KIRKLEES METROPOLITAN COUNCIL INVESTMENT & REGENERATION SERVICE

DELEGATED DECISION TO DETERMINE PLANNING APPLICATIONS

Reference No:	2025/62/91157/W
Site Address:	62, Burfitts Road, Oakes, Huddersfield, HD3 4YL
Description:	Erection of two storey side and rear extension, erection of pergola, creation of means of access and associated parking, retaining walls and works.
Recommending Officer:	John Holmes

Officer Report – 2025/91157

Drawing No
 (100)04

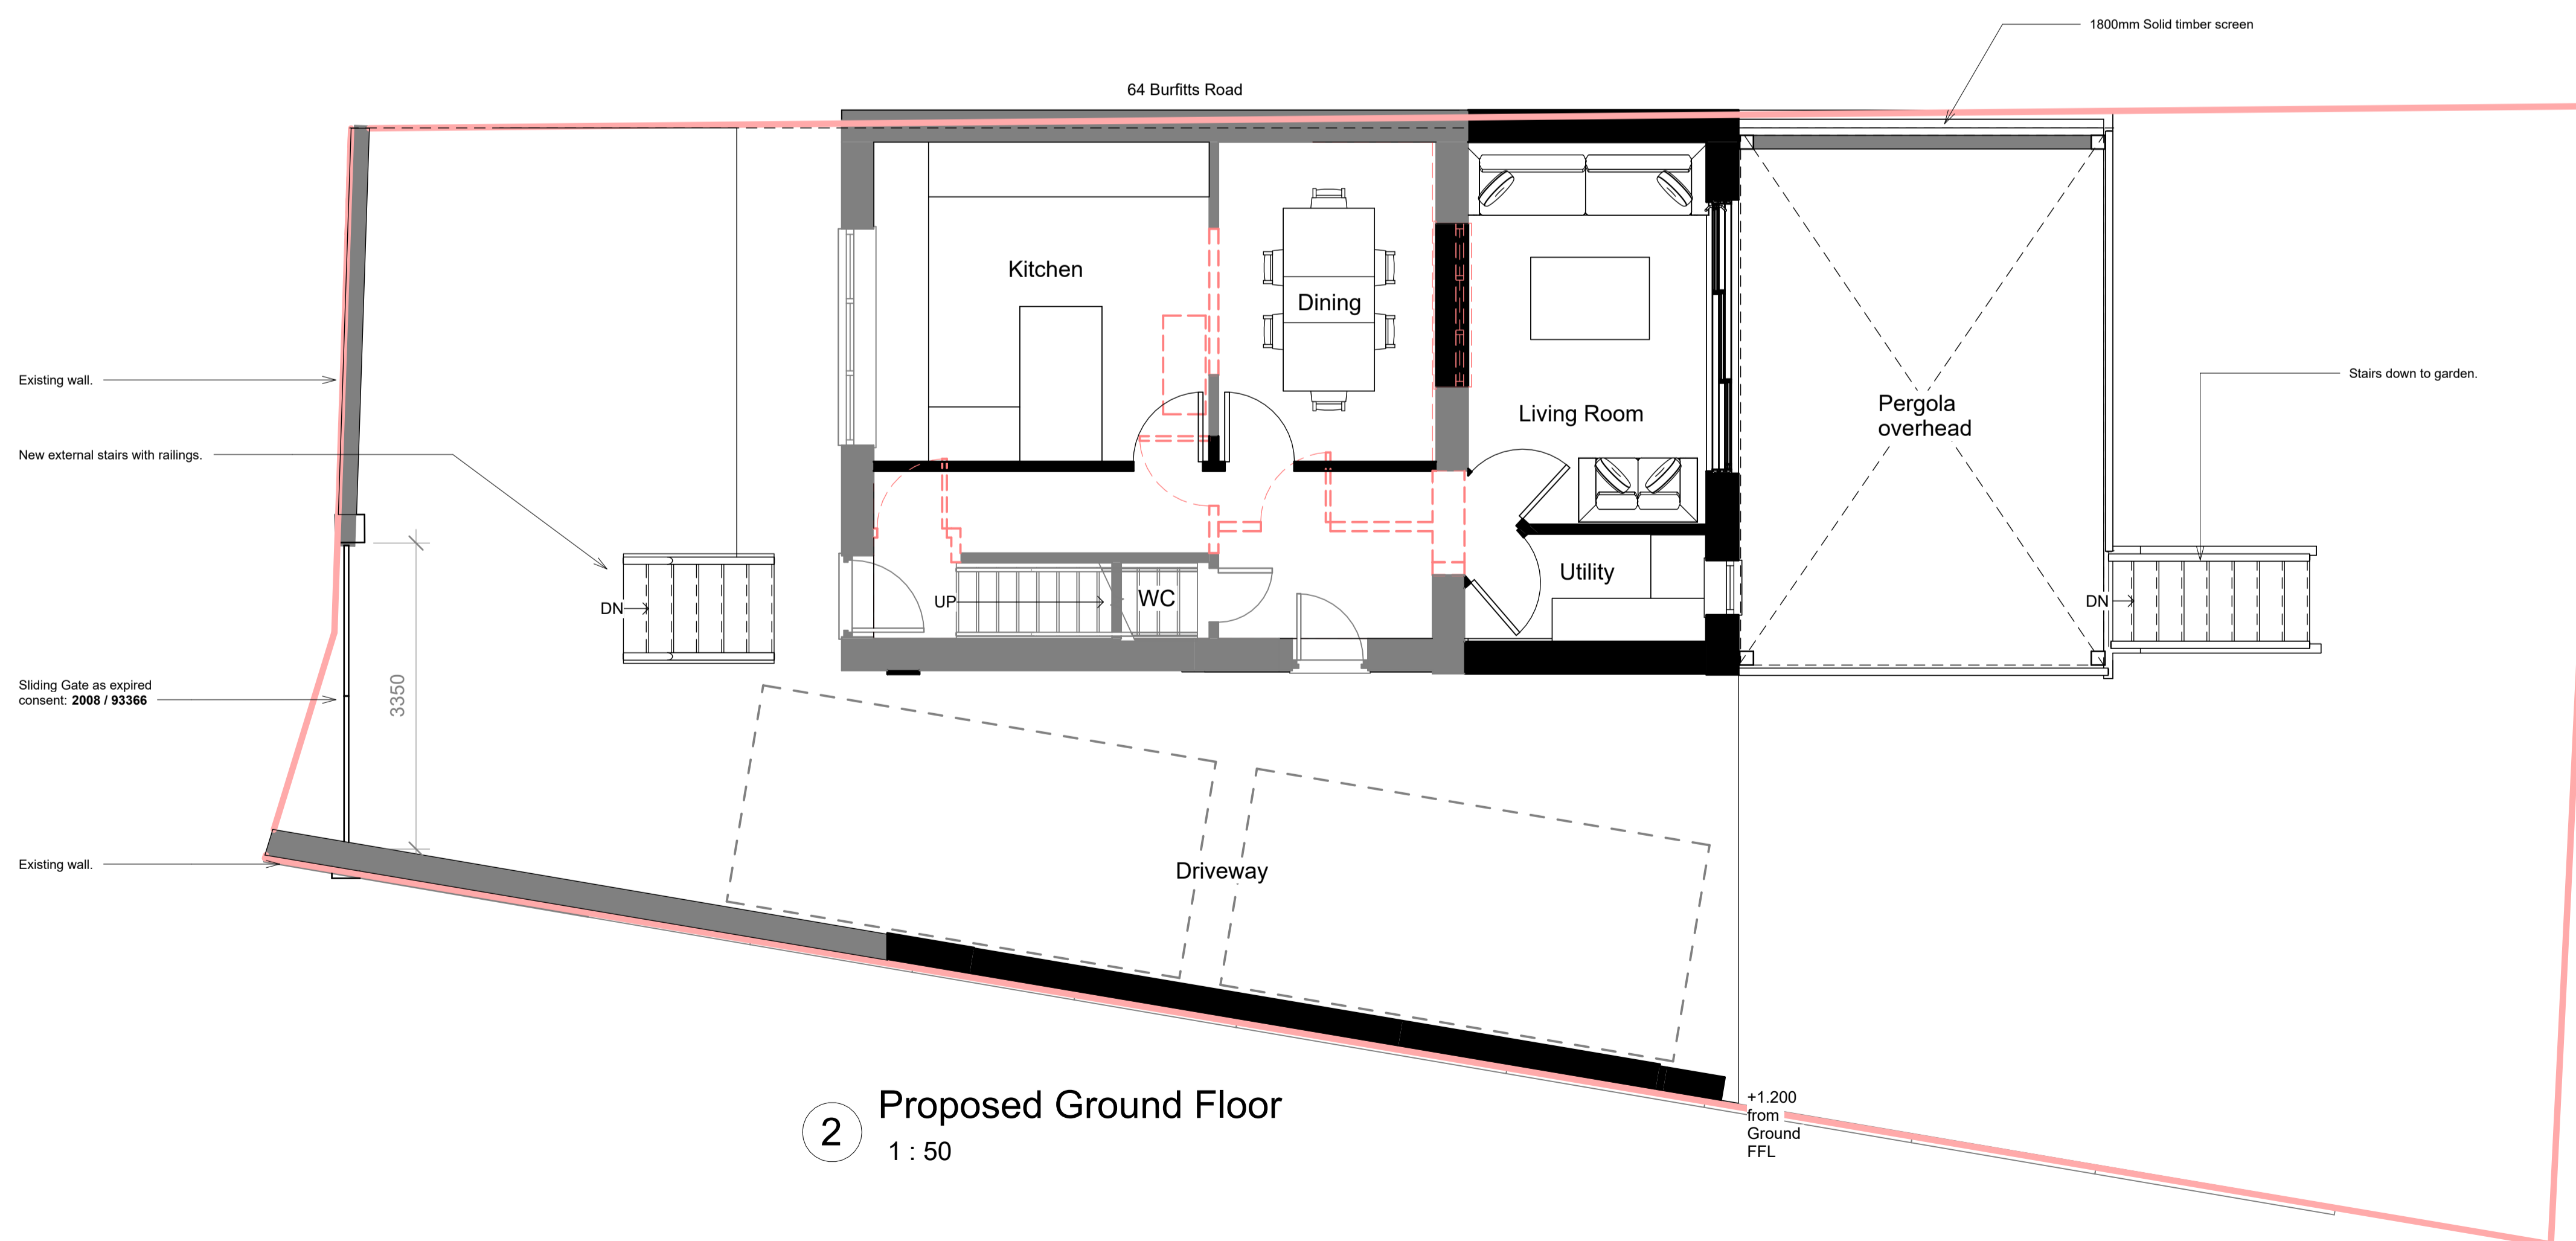
The proposal would see the provision of parking to the side and rear, the parking is demonstrated to provide 2 spaces although it appears there is potential for 3 spaces to be provided given the 15m length driveway (and the fact it could potentially extend further to the rear). As such it is considered the proposal would have an acceptable impact in terms of vehicular parking provision particularly when considering retention of soft landscaping to the site frontage it is considered a suitable balance between ensuring an acceptable visual impact to prominent parts of the site and the provision of vehicular parking off street is achieved.

It is considered necessary to ensure that the areas outlined and dotted grey upon submitted plan (100)revB are retained for vehicular parking for the lifetime of the development to ensure suitable parking arrangements are retained in perpetuity and this would be achieved through an appropriately worded condition.

Project No 2937	Drawing No (100)05	Rev B
--------------------	-----------------------	----------

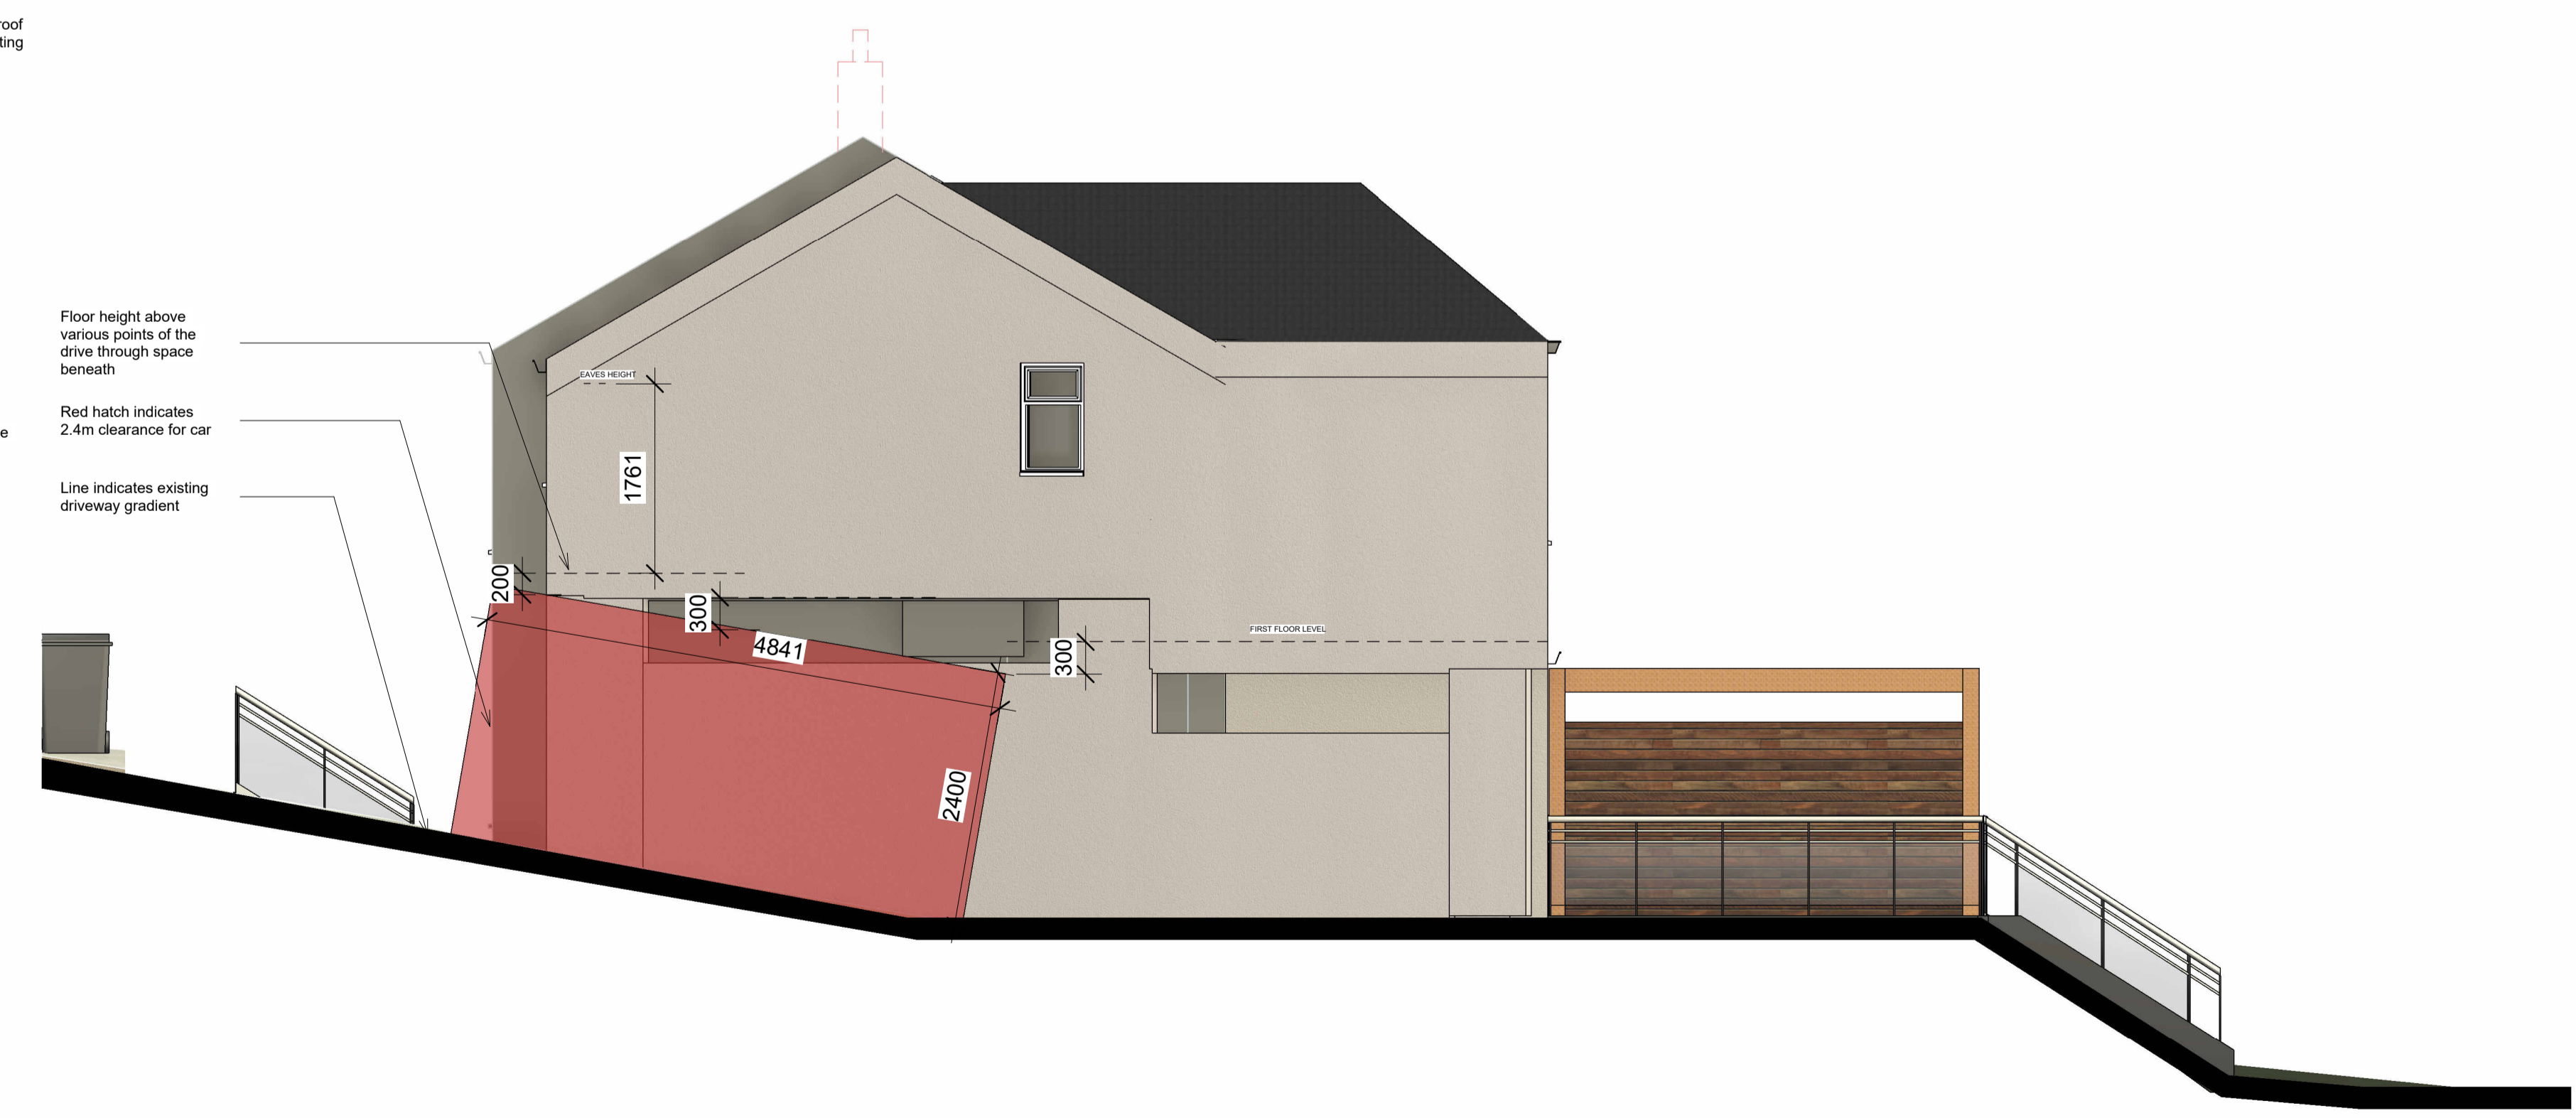
Turning to the pergola, this element was initially open sided, however has been amended to incorporate a screen within the structure. It is noted this screen is of a size over 3m when measured from the ground level. The pergola / decking area requires an element of underbuild to allow it to provide a level access at the rear of no.62.

It is concluded that when balancing up a number of factors, including the setting in of the privacy screen, the size it is sited above ground level, the downwards sloping of the rear amenity space and the orientation of the site, the impact of the proposal is not considered to constitute a reason for refusal which could be substantiated by the Local Planning Authority (LPA) in this case. There would be a degree of additional enclosure created by the development the subject of this application, however this is mitigated by the heights of the elements along the shared boundary with no.64 and the setting in of the pergola screening. On balance, the proposal is concluded to be acceptable in this regard.

It is recommended any approval is subject to condition requiring the privacy screen annotated 'new timber screen' upon submitted drawing (100)05revB is provided before the development is brought into use.

3. The privacy screen annotated 'new timber screen' upon submitted drawing (100)05revB shall be completed before the development is brought into use.
